**KIRKLEES METROPOLITAN COUNCIL
INVESTMENT & REGENERATION SERVICE**

DELEGATED DECISION TO DETERMINE PLANNING APPLICATIONS

Reference No: 2020/62/94268/E
Site Address: 132, South View Road, East Bierley, BD4 6PJ
Description: Erection of two storey side and single storey rear extensions and boundary wall to front
Recommending Officer: Alice Downham

DECISION – CONDITIONAL FULL PERMISSION

PROPOSED GROUND FLOOR PLAN VIEW
SCALE 1:50

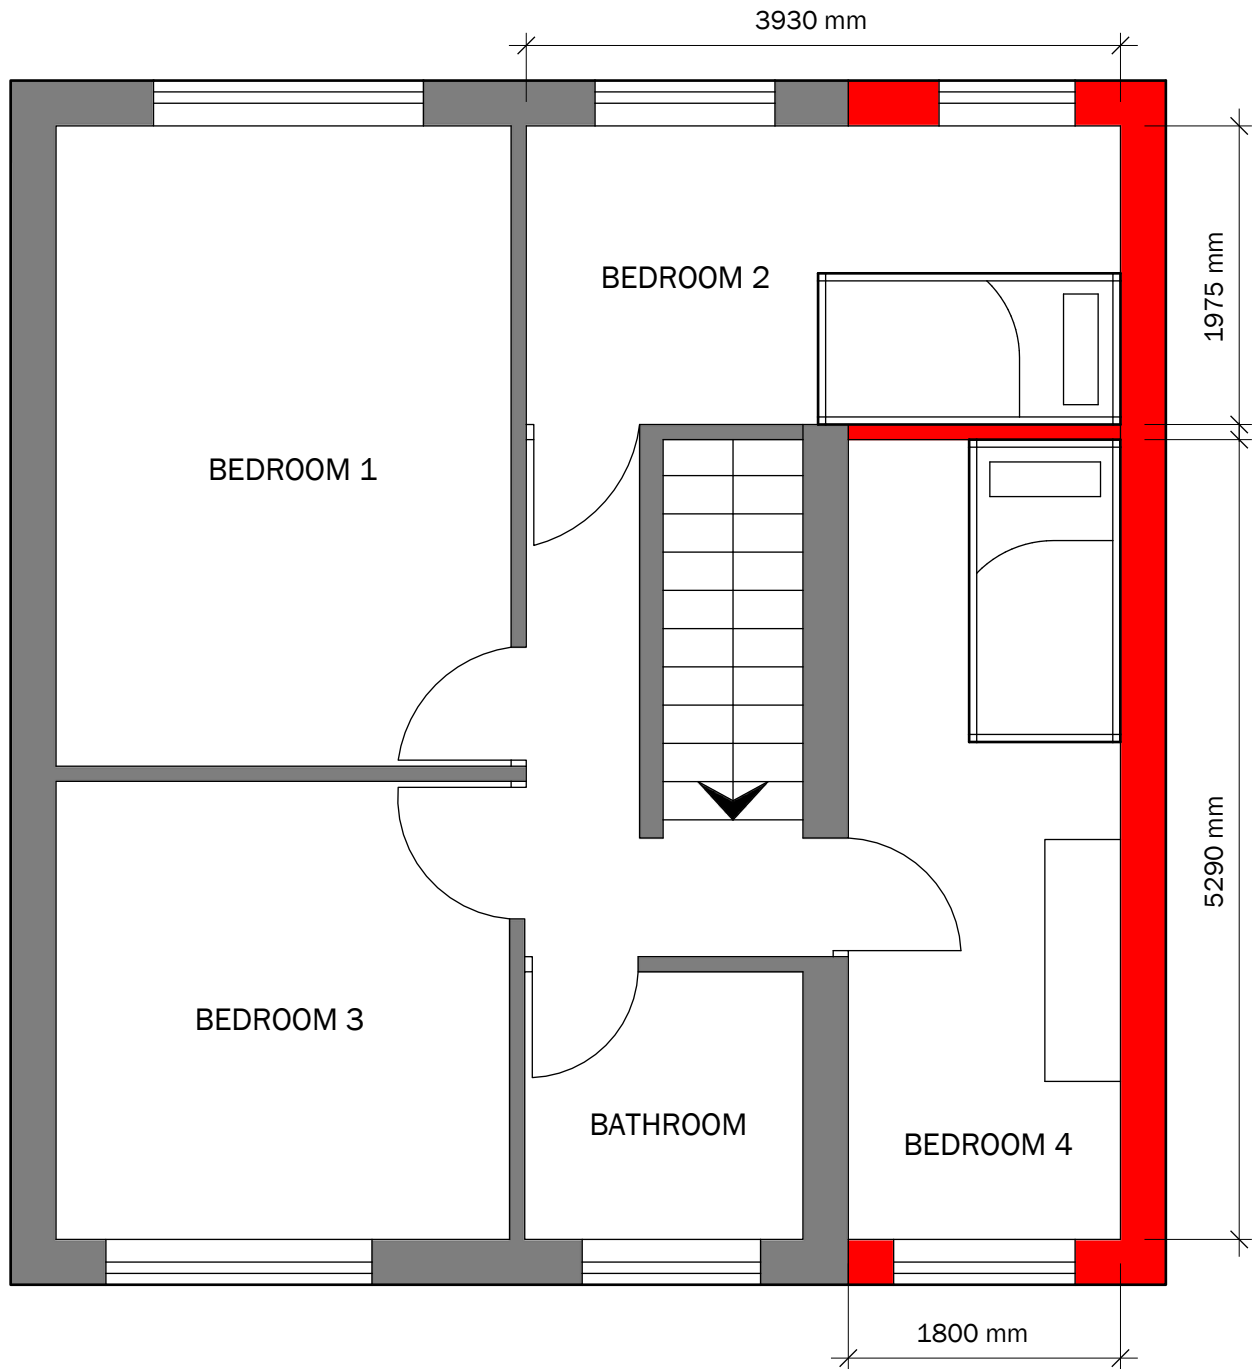
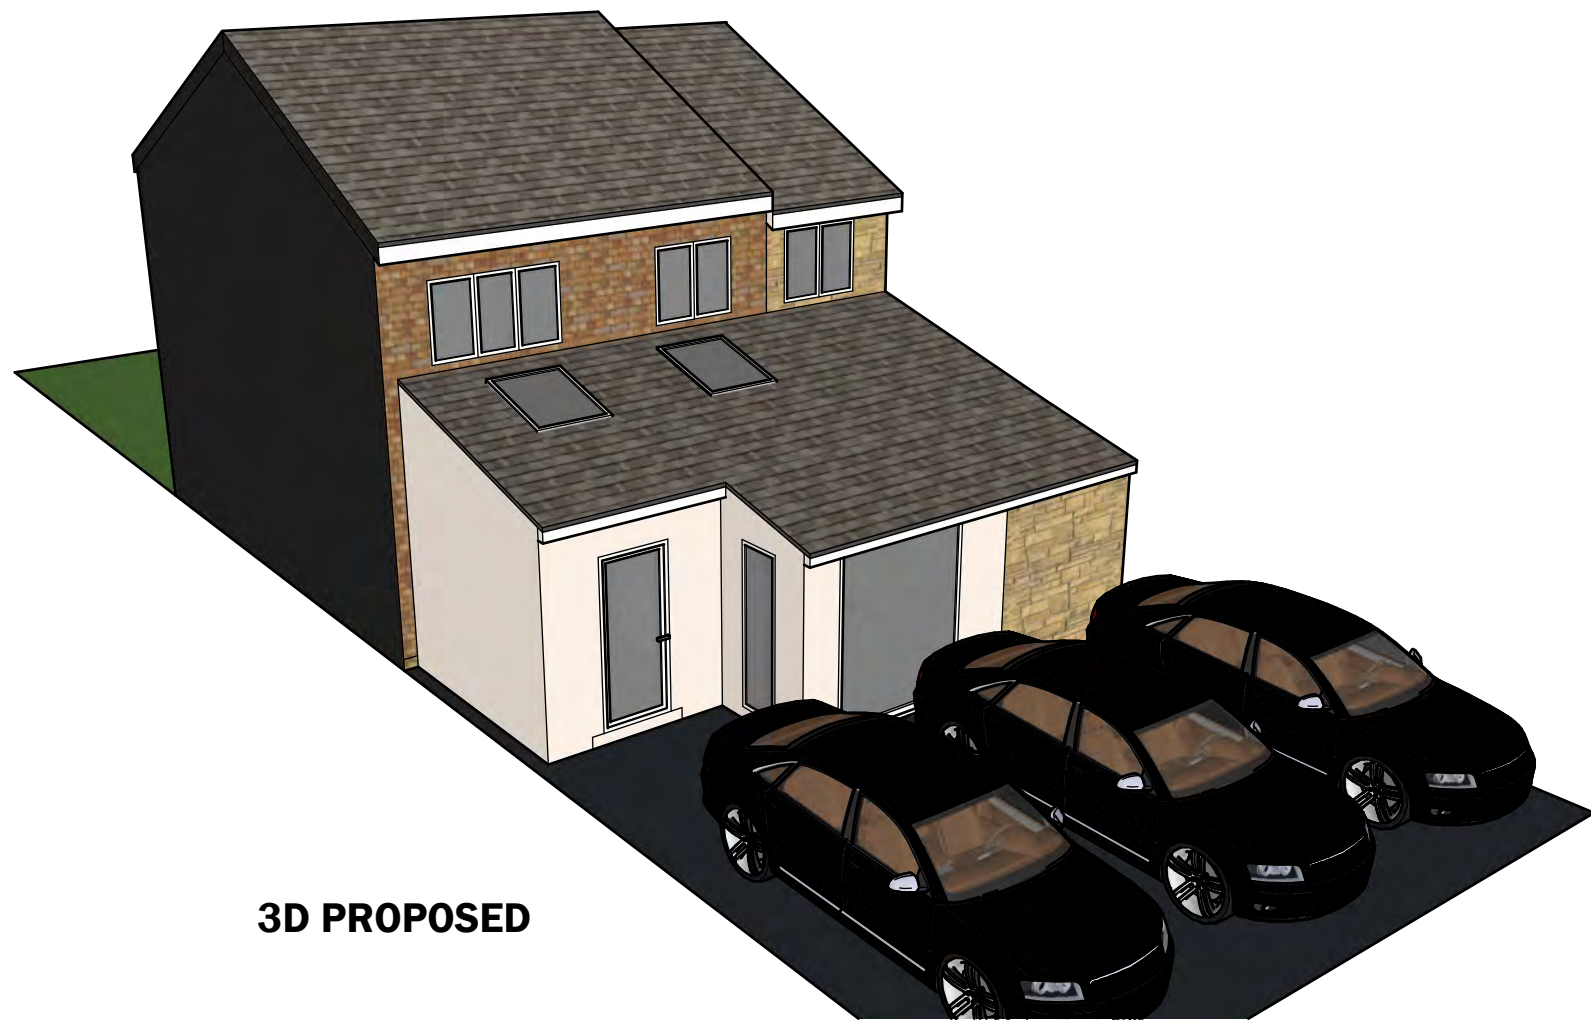
After a discussion with the Council's Conservation and Design team, concerns were raised regarding the potential harm to the East Bierley Conservation Area. To mitigate the impact, officers suggested that the front elevation of the side extension is set back by 0.5m, to appear subordinate to the host dwelling, and that the front elevation of the side extension be clad in brick (to match the host dwelling) rather than stone. The agent submitted amended plans showing these changes, which are considered acceptable.

Loss of privacy due to moving rear entrance
Comment: *Amended plans were received which show that the rear entrance to the applicant property would remain in a similar position relative to the neighbouring properties. Therefore, there would be no loss of privacy.*
